EL PASO COUNTY
STORMWATER MANAGEMENT PLAN CHECKLIST
 LATIGO-EASTONVILLE 8" PVC RAW WATERMAIN

EL PASO COUNTY STORMWATER MANAGEMENT PLAN CHECKLIST

MERIDIAN SERVICE
METROPOLITAN DISTRICT
LATIGO EASTONVILLE WATER
PIPELINE
PLAN AND PROFILE

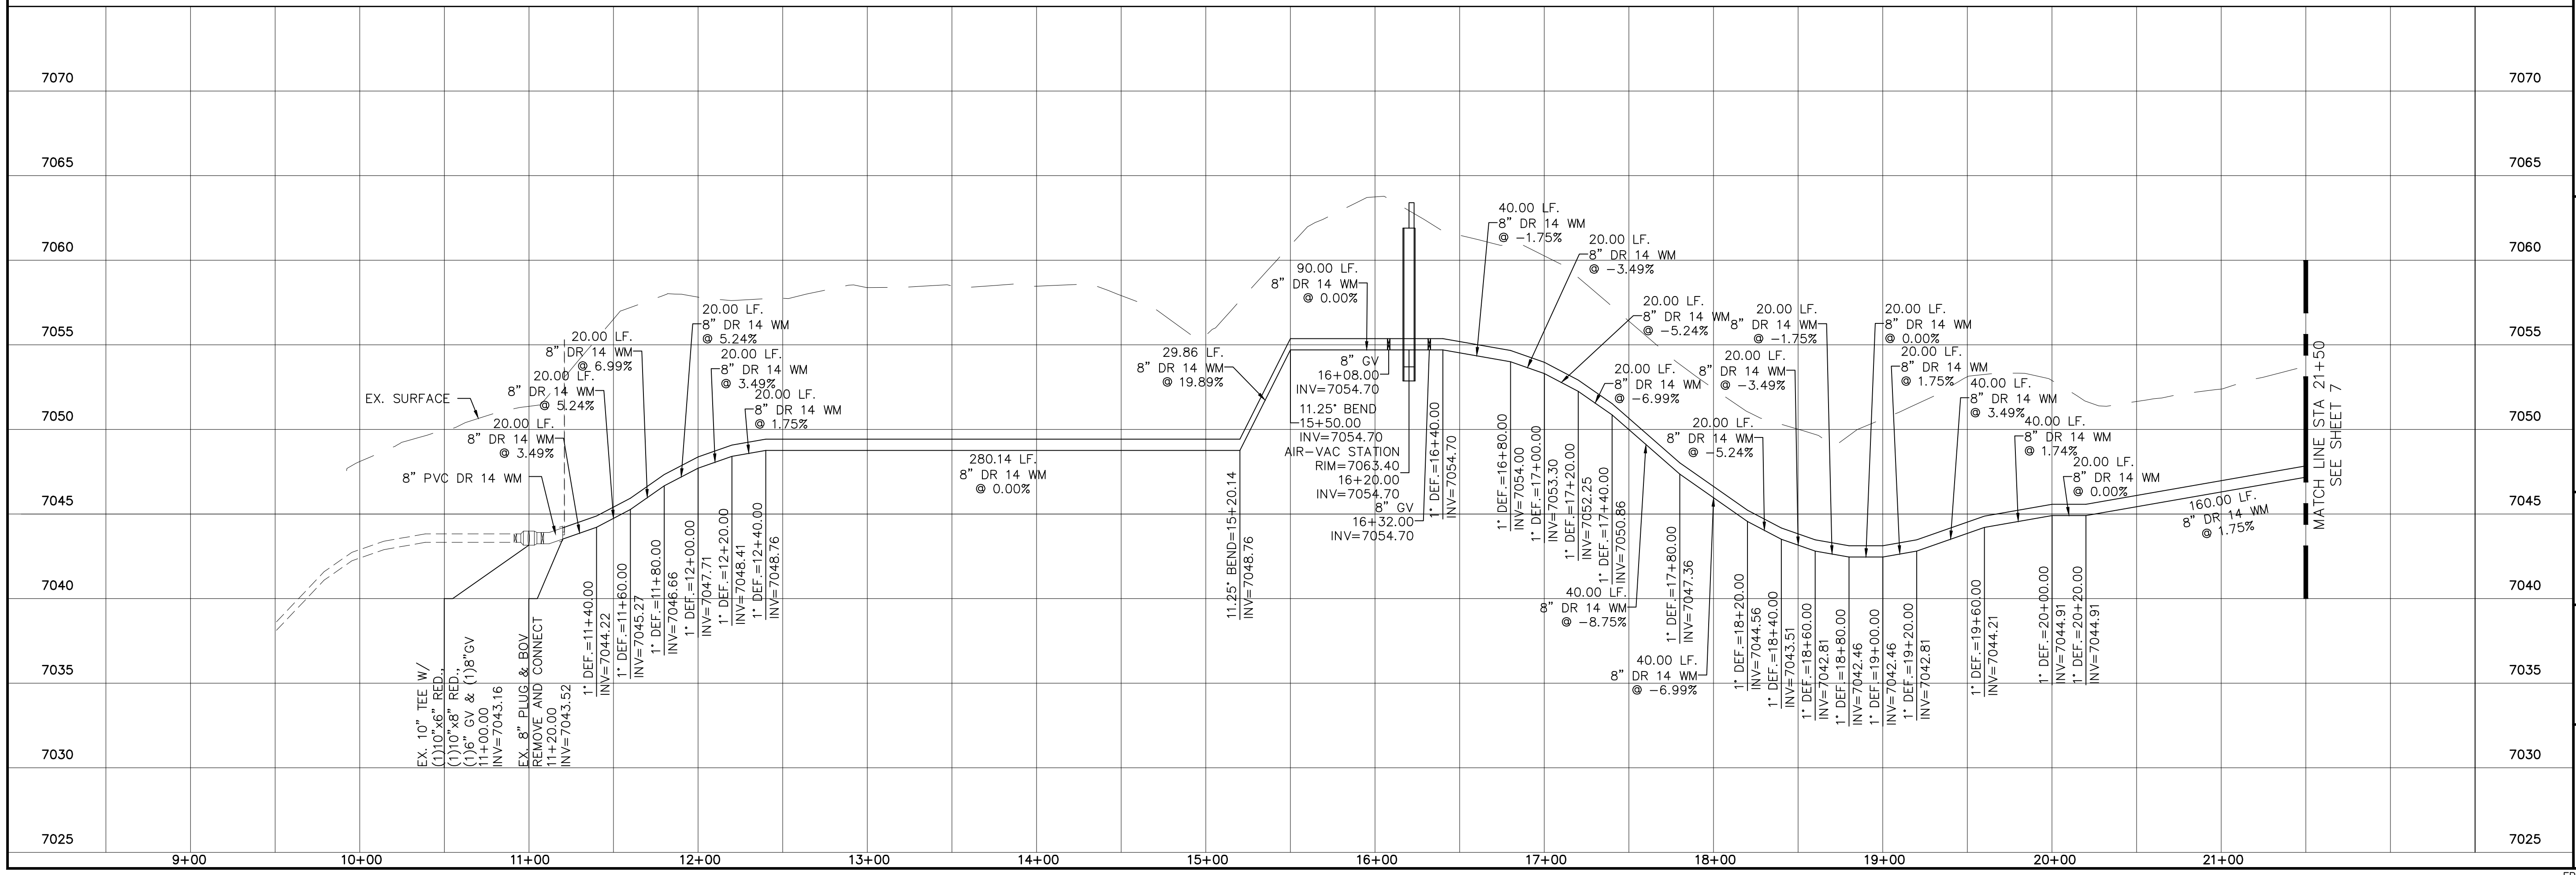
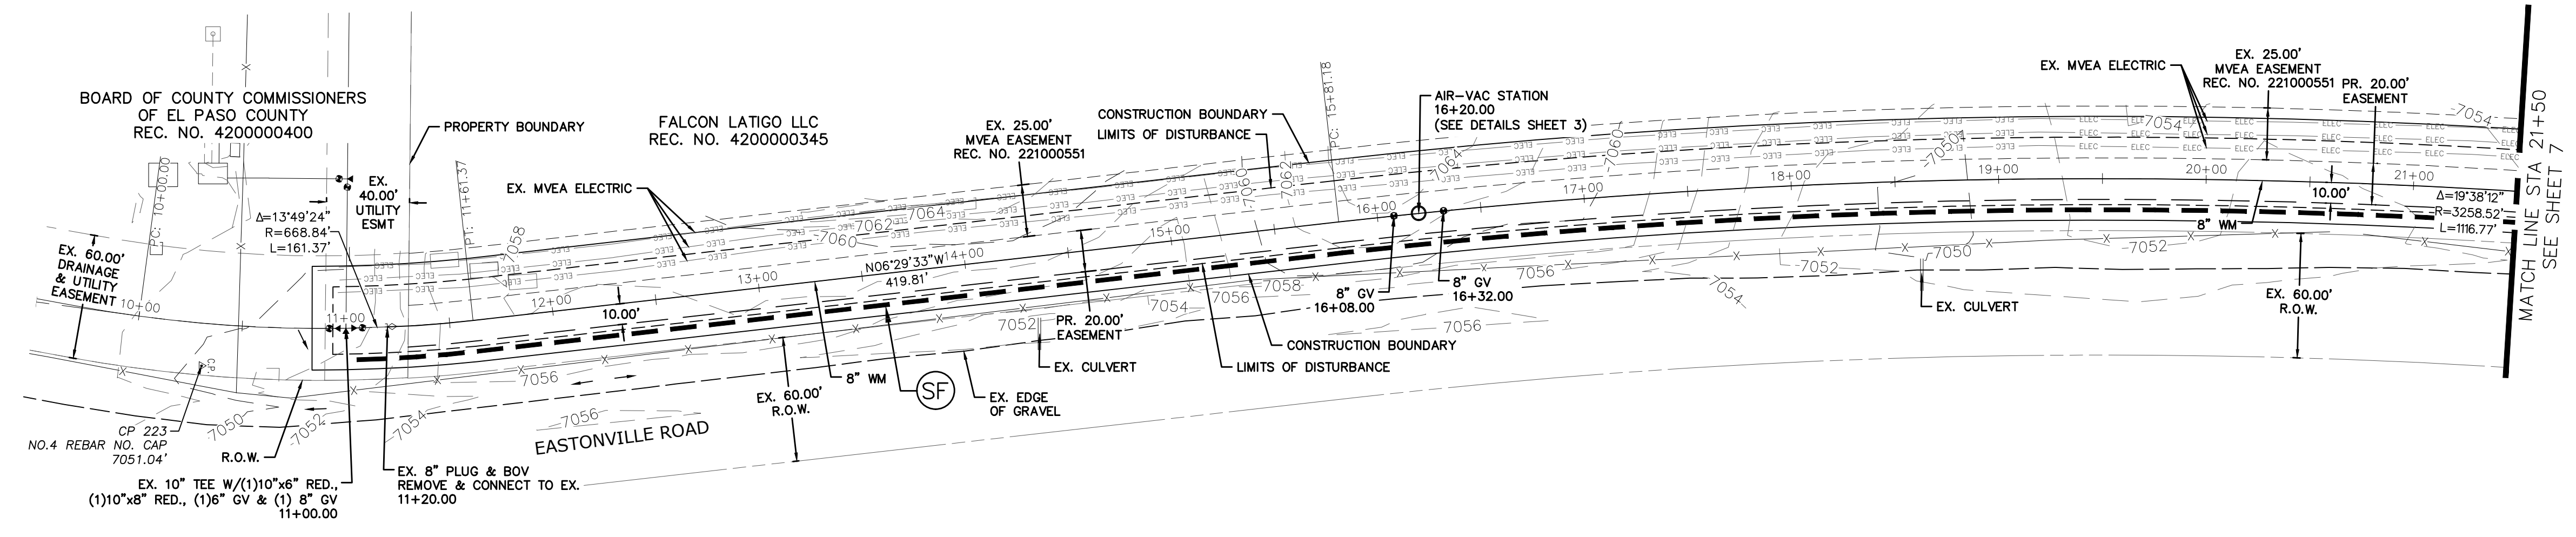
Applicant	EPC
17	SWMP Map to include: GEC Plan reviewed		
17a	construction site boundaries		Y
17b	flow arrows to depict stormwater flow directions		N
17c	all areas of disturbance		Y
17d	areas of cut and fill		Y
17e	areas used for storage of building materials, soils (stockpiles) or wastes		Y
17f	location of any dedicated asphalt / concrete batch plants		Y
17g	location of all structural control measures		Y
17h	location of all non-structural control measures		N
17i	springs, streams, wetlands and other surface waters, including areas that require maintenance of pre-existing vegetation within 50 feet of a receiving water		Y
18	Narrative description of all structural control measures to be used. Modifications to EPC standard control measures must meet or exceed County-approved details		Y
19	Description of all non-structural control measures to be used including seeding, mulching, protection of existing vegetation, site watering, sod placement, etc.		Y
